October 31, 2018

RE: **Holly Senior Living**
9100 Holly Ave NE
Conceptual Grading and Drainage Plan
Engineer's Stamp Date: 10/17/18
Hydrology File: C20D079

Based on the submittal received on 10/23/18, this project cannot be approved for Site Plan Building Permit until the following are corrected and a complete resubmittal is made:

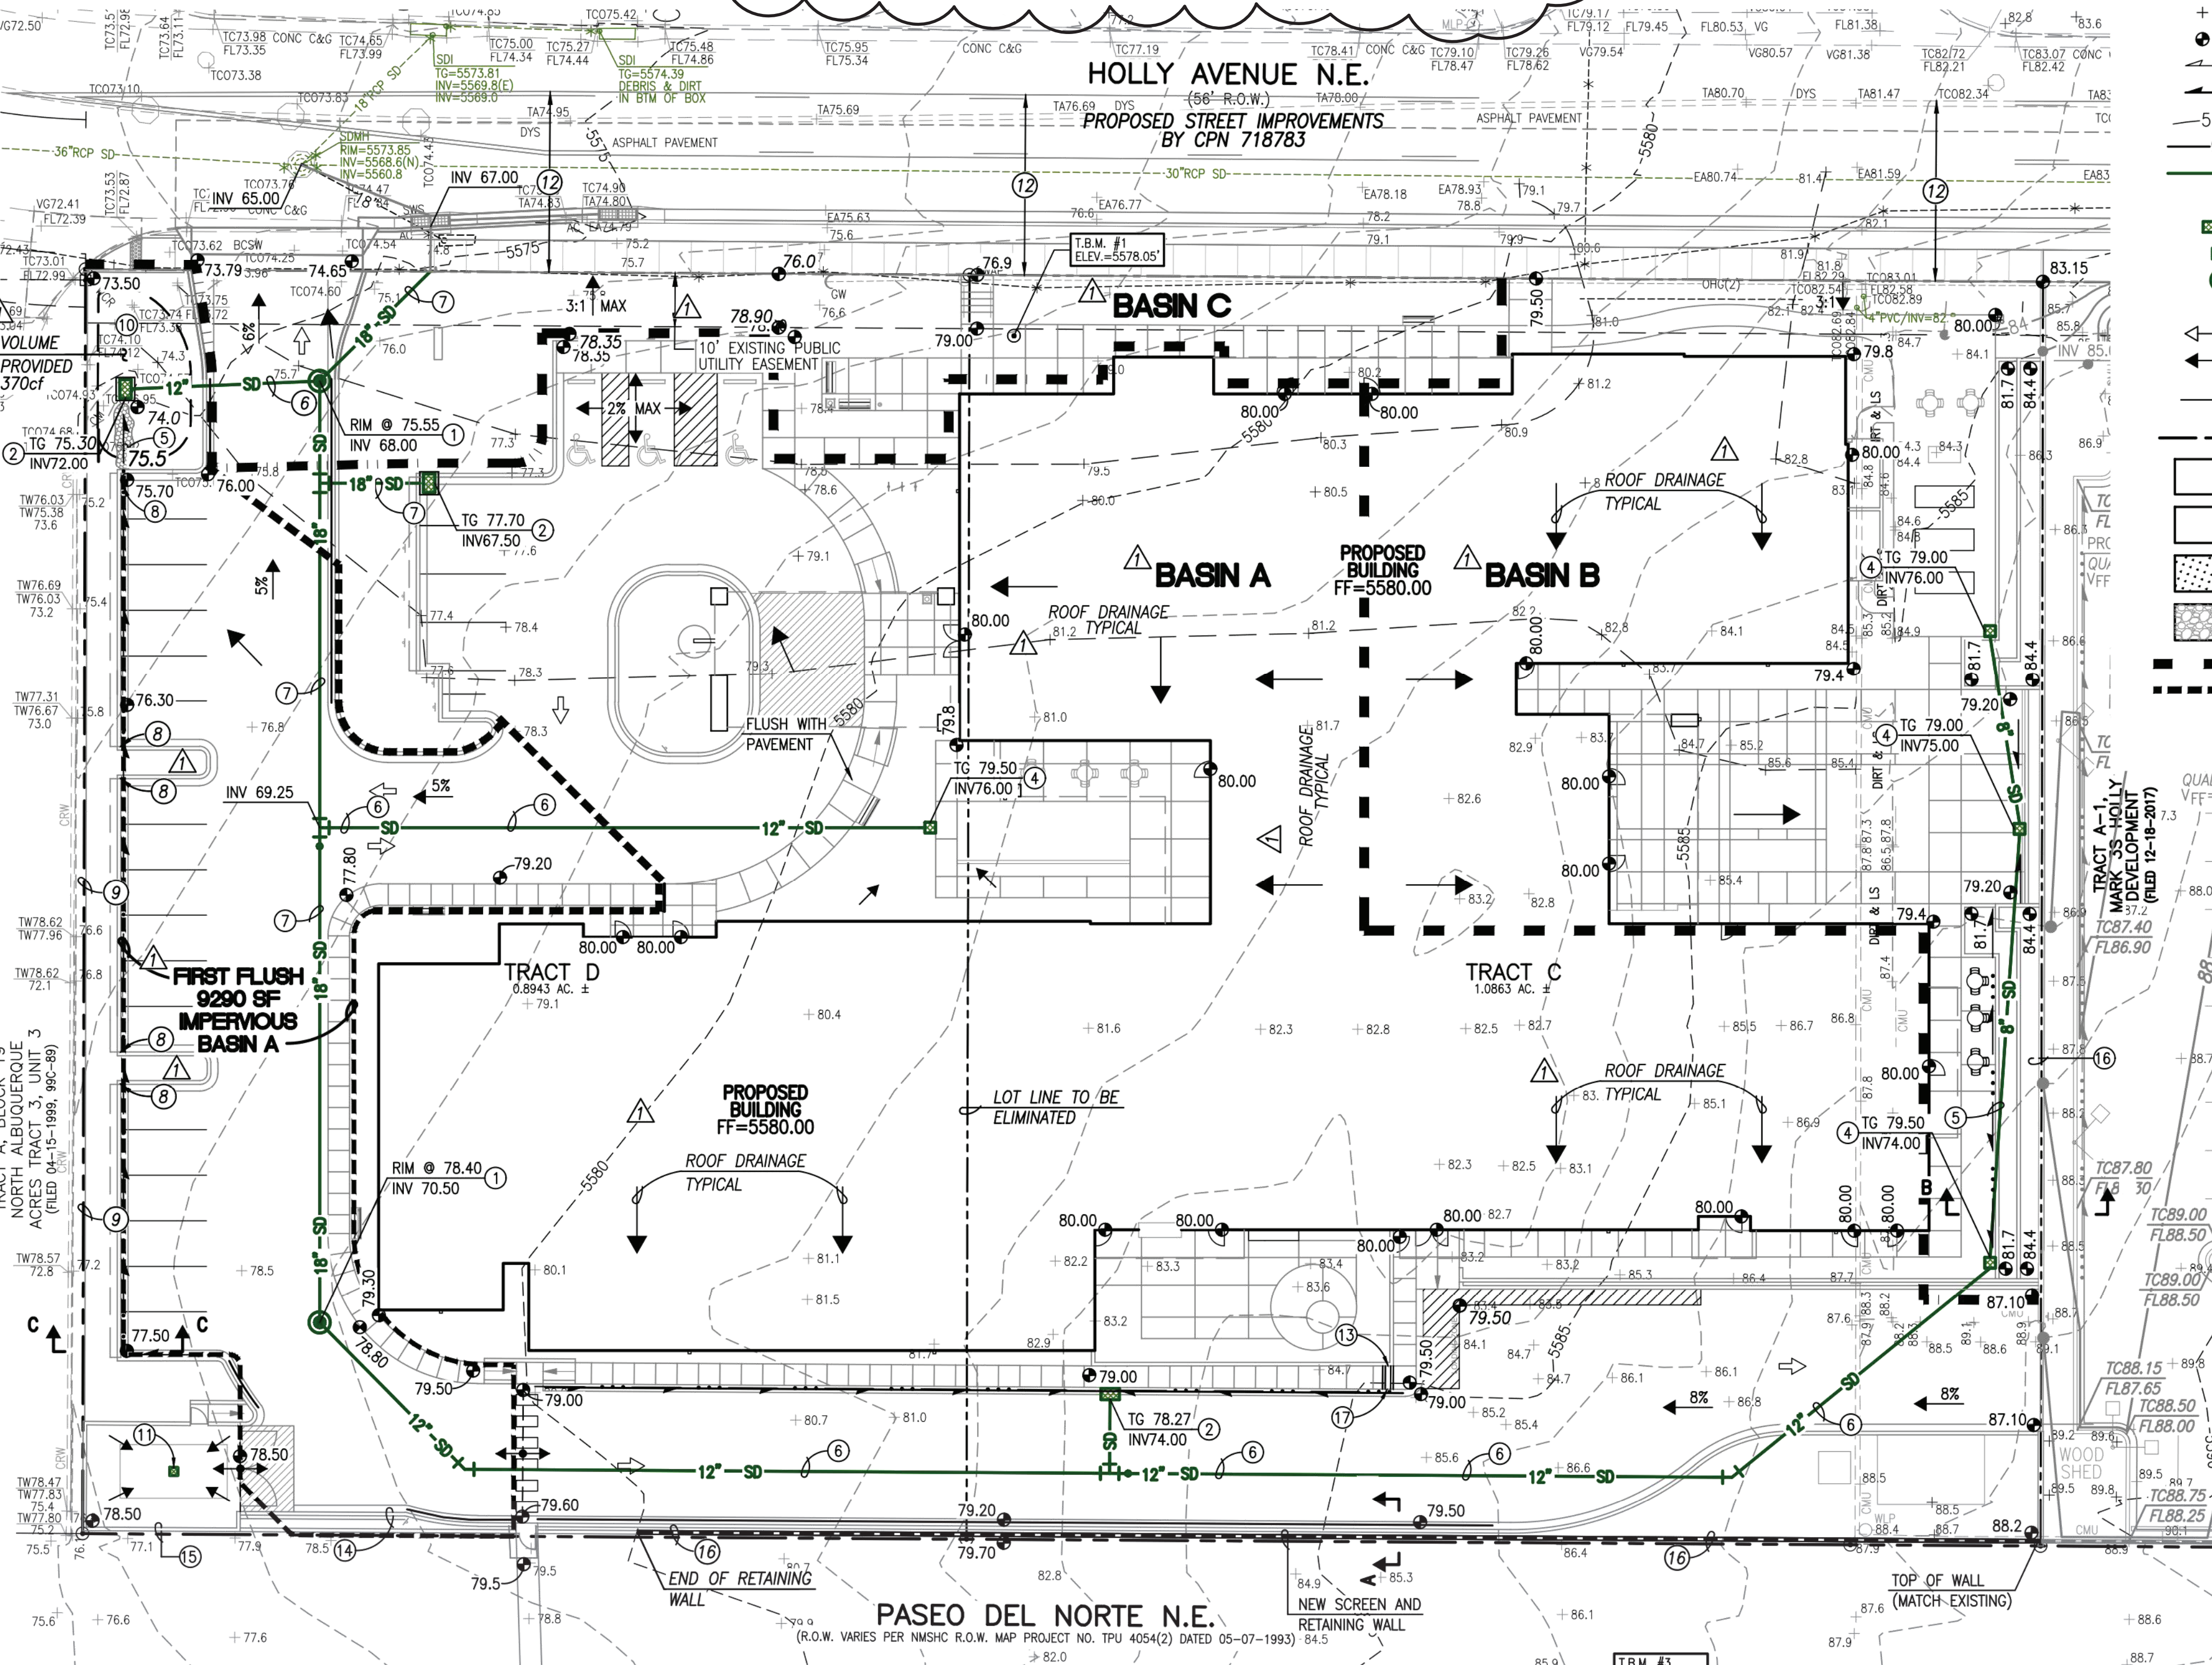
1. Provide structural drawings and calculations for the retaining walls at section B-B demonstrating that a wall with no footer will retain 3.6' of soil. Provide structural drawings and calculations for the retaining walls at section A-A demonstrating that the wall with reversed footer will retain 4.4' of soil. All structural drawings and calculations will need to be stamped by a structural engineer.

2. If the proposed retaining wall footer for Section B-B or Section A-A encroaches on the neighboring property; provide written permission from the adjoining property owner for this work. Written permission must include: signature of the property owner or owners representative, statement that undersigned is the owner or authorized representative, permission to construct the encroachment with a brief description of the encroachment.

3. Define the areas expected to route through first flush facilities and those that will bypass. State the first flush bypass volume on the plans.
